Recommendation Report for Consent to Display an Advertisement(s)

REF NO: AB/25/18/A

LOCATION: The Swan Hotel
27-29 High Street
Arundel
BN18 9AG

PROPOSAL: Various internally & externally illuminated signs on various elevations.

Page 4 of 8

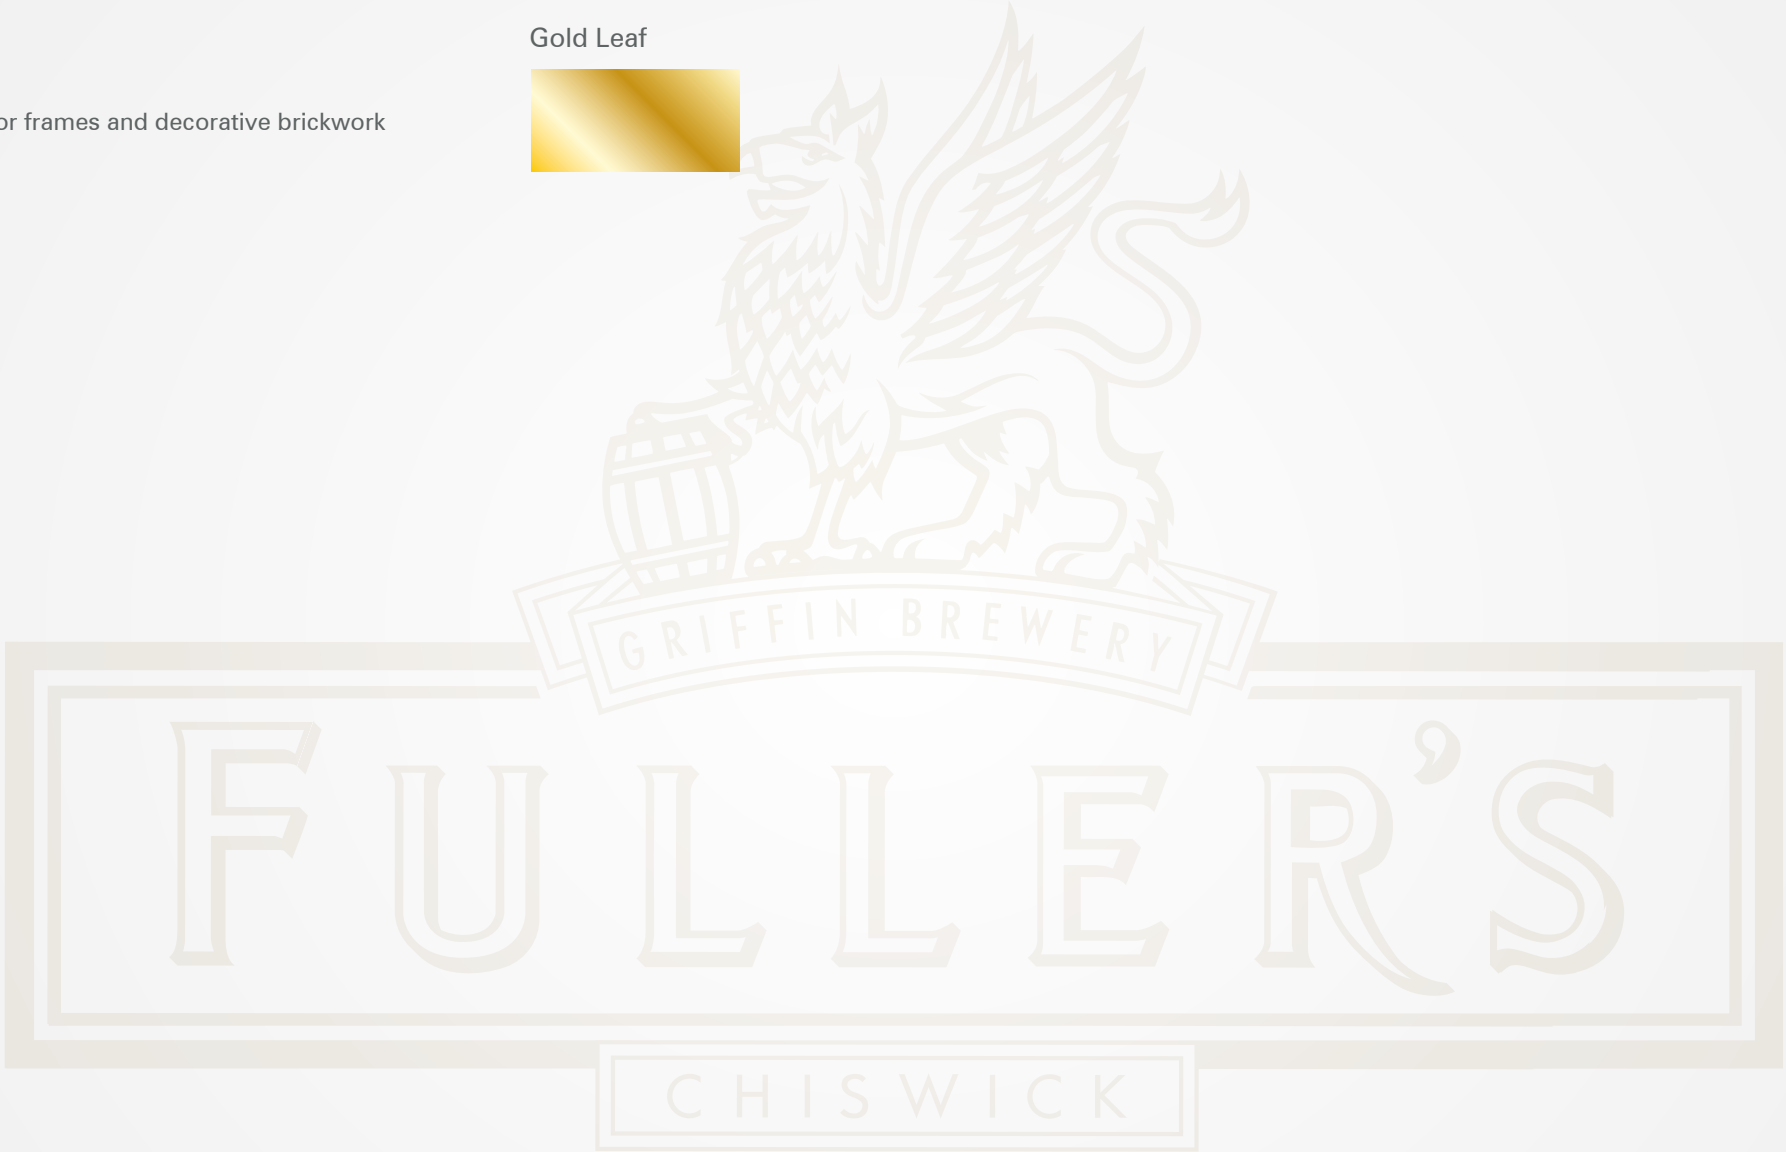
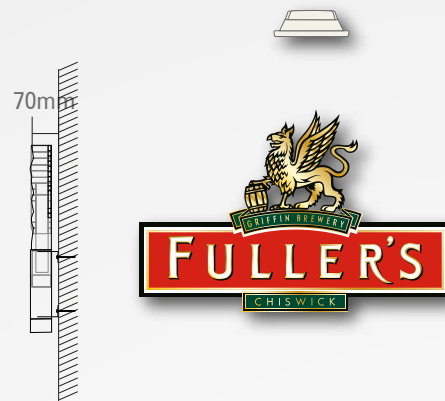
'with regard to the lighting , it is considered that the current level of lighting be sufficient to illuminate signage, and that there be no net increase....'

Officers note that the amended set of plans, Issue 7, do not seek to add any additional signs or alter the colours of the signs or their siting or the application property from that shown on earlier plans e.g. the Issue 6 set of plans. As such, it is considered that as amended Plans Issue 7 only seek to remove some of the previously proposed lighting and as such advertisement consent is warranted.

As aforementioned, it should be noted that following comments from the conservation Officer, re: the accompanying Listed Building application ref: AB/26/18/L, changes to the original scheme have been made with particular regard to the level of proposed lighting. From an assessment of the amended plans it is noted that a number of the previously proposed LED lights have been removed to reduce the number of lights.

PROPOSED ELEVATIONS

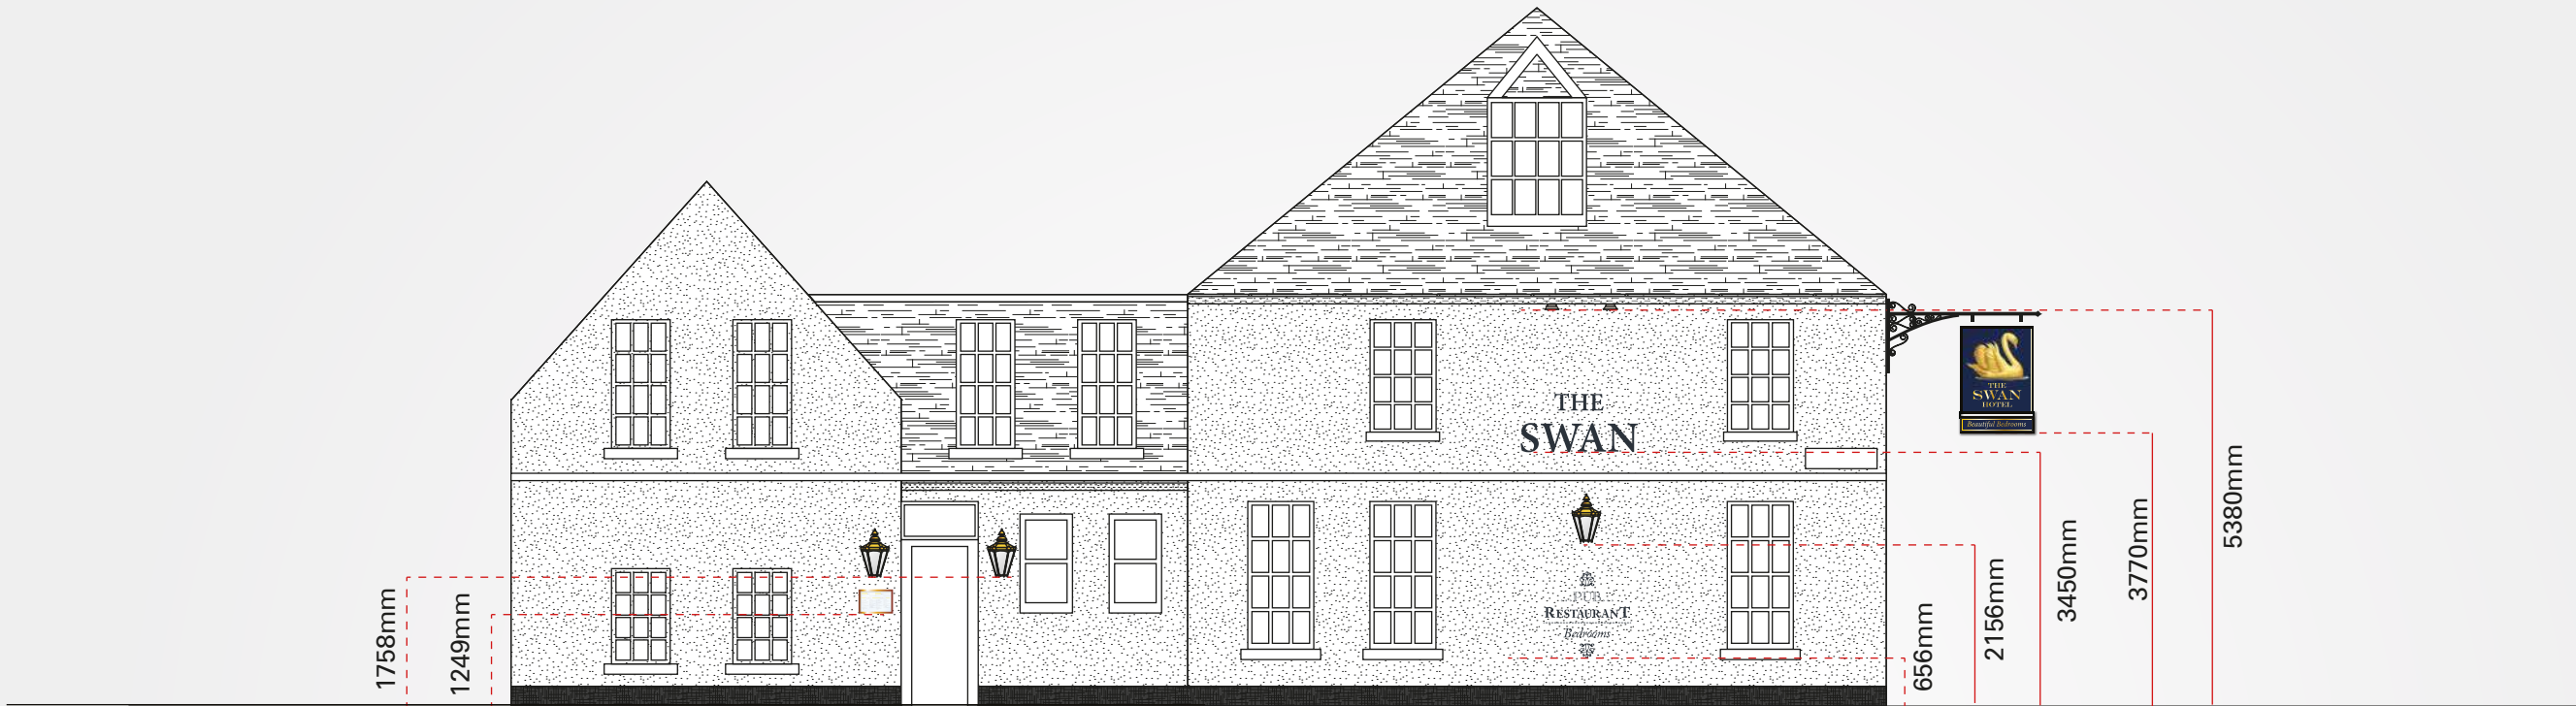
'The Committee maintain their previous objection that the additional illumination would result in excessive light spillage that would detract from the character and appearance of this part of the Conservation Area. As to the revision, the details on the amended plans are so poor that members could not differentiate between the original and substituted colour pallets and signage dimensions

'The Committee considered that the additional illumination would result in excessive light spillage that would detract from the character and appearance of this part of the Conservation Area.'

From an assessment of the signs, as shown on amended Plans set Issue 7, it is considered that they are acceptable subject to appropriate illuminance levels. A condition regarding the illuminance levels would be imposed upon any grant of Advertisement Consent. They are of an acceptable design and would preserve the appearance of the street scene and Conservation Area.
